Lovely Hall, Lovely Hall Lane, Salesbury, Lancashire, BB1 9EQ. Application No. 3/2020/0853

Thank you for consulting the Council for British Archaeology (CBA) on the above case. Based on the information supplied with this application, we offer the following observations and advice to assist your authority in determining the application.

Existing Plans
First Floor and Roof

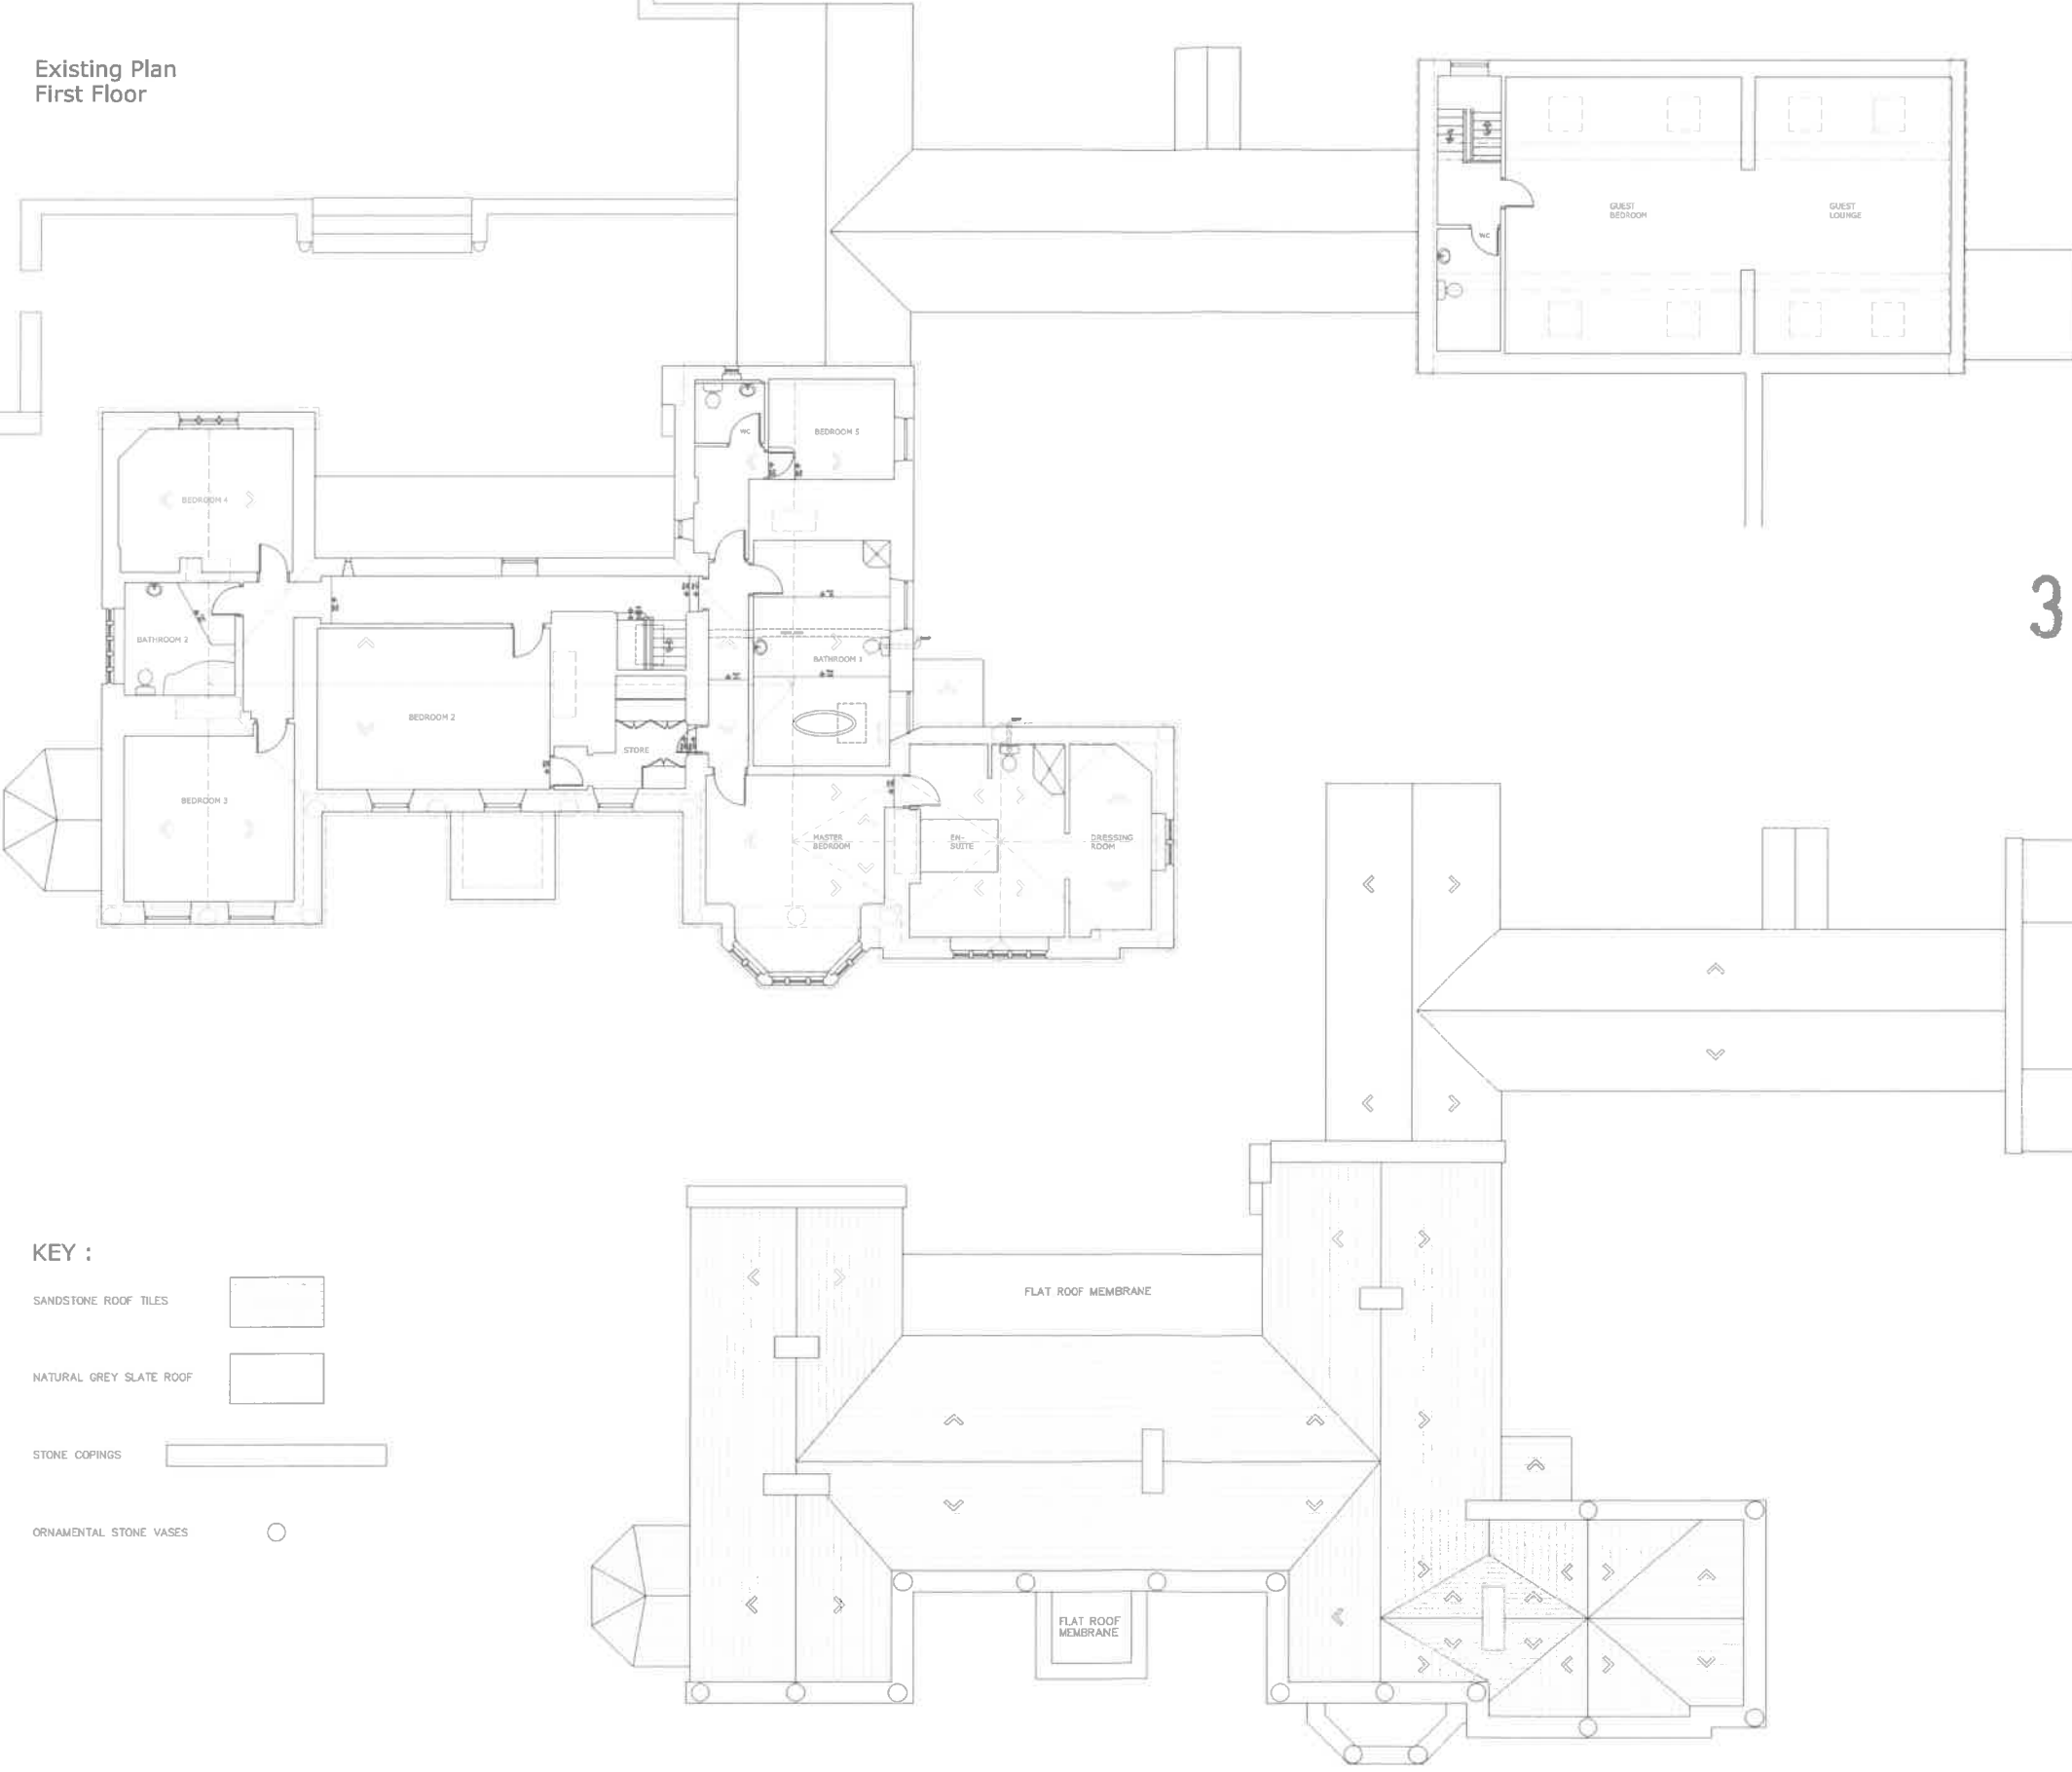
These proposals will primarily impact upon the historic roof structure of Lovely Hall. We would therefore expect the significance of the roof to be focused on within the heritage assessment. We suggest that supplementary information is necessary to understand the significance, condition and impact of the proposed works on the roof before any permissions are undertaken.

The submitted woodworm report suggests that the historic roof structure is largely intact. Although scant detail is provided. The historical and evidential values associated with the structure will contribute to the building's significance. In order to satisfy the requirements of paragraph 193 of the NPPF the CBA recommend that a scheme of works should be submitted which demonstrates a conservation led methodology for any works to the roof structure. An appropriate methodology should seek to repair and strengthen the extant timbers rather than replace them. This is likely to necessitate the use of contractors with experience of historic roof structures and

We also recommend that a survey of the extant roof structure, evidencing its condition and informing its conservative repair should be required, although we acknowledge this may be achieved through conditions attached to any permissions your Authority may be minded to grant.

Lovely Hall Lovely Hall Lane Salesbury Blackburn BB1 9EQ	scale 1:50 at A1 October 2020
LH1-05 PPY design Ltd	Proposed Plans First Floor

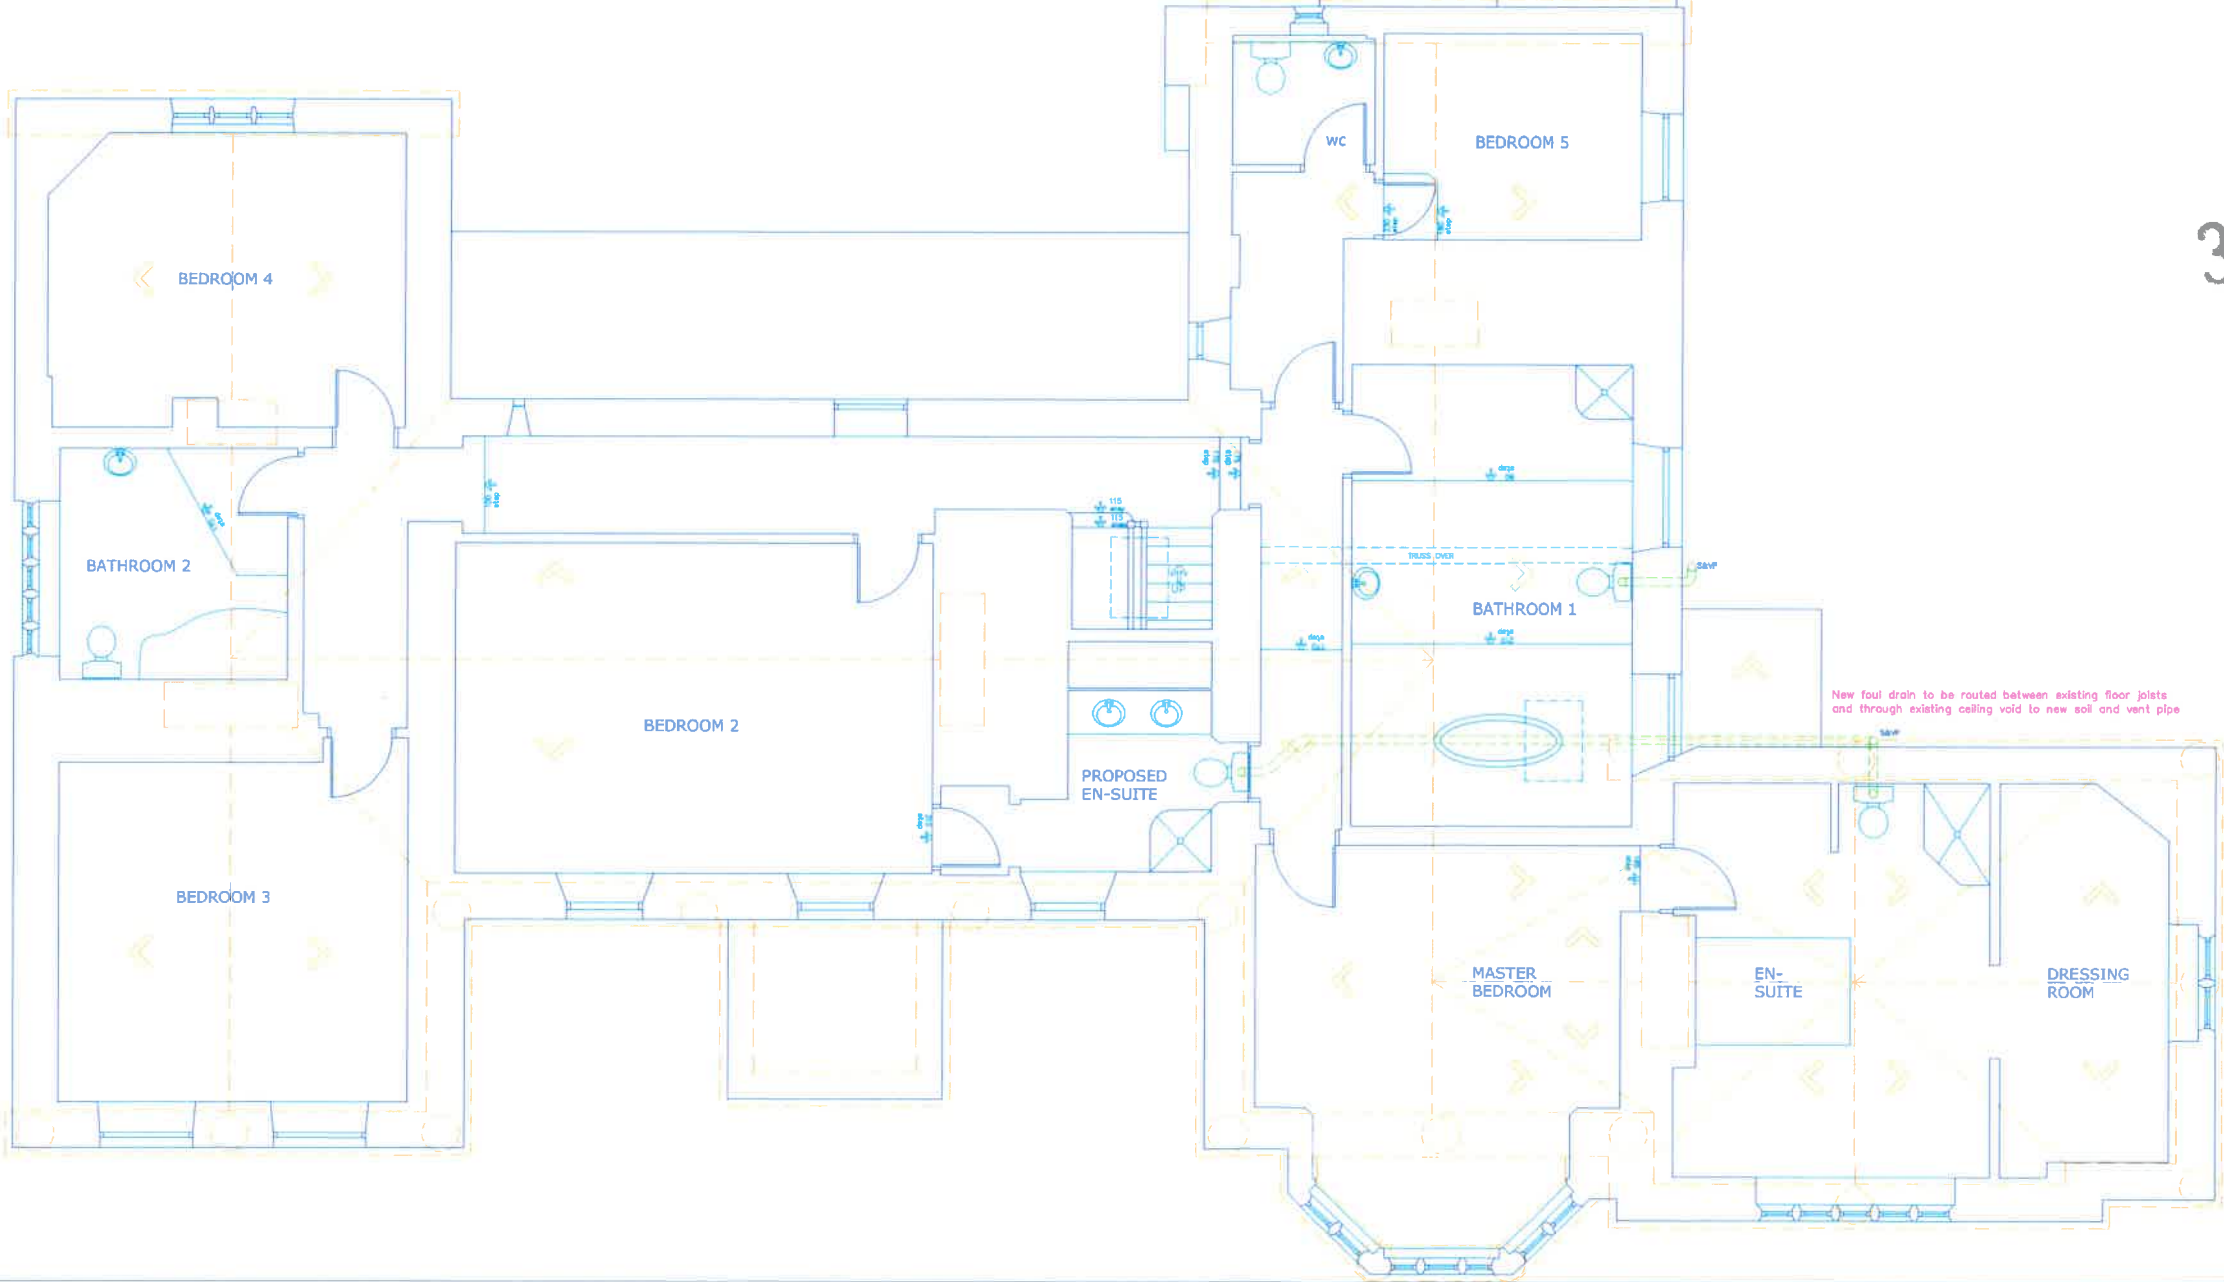
The CBA advise that further information is also necessary in order to understand the potential impact of introducing plumbing and drainage runs to the proposed bathroom on the building's historic fabric. In this regard we recommend that paragraphs 193 and 194 of the NPPF will be pertinent.

The CBA recommend that a greater understanding of the potential impacts of introducing plumbing to the proposed en suite is necessary before determination of this aspect of this application.
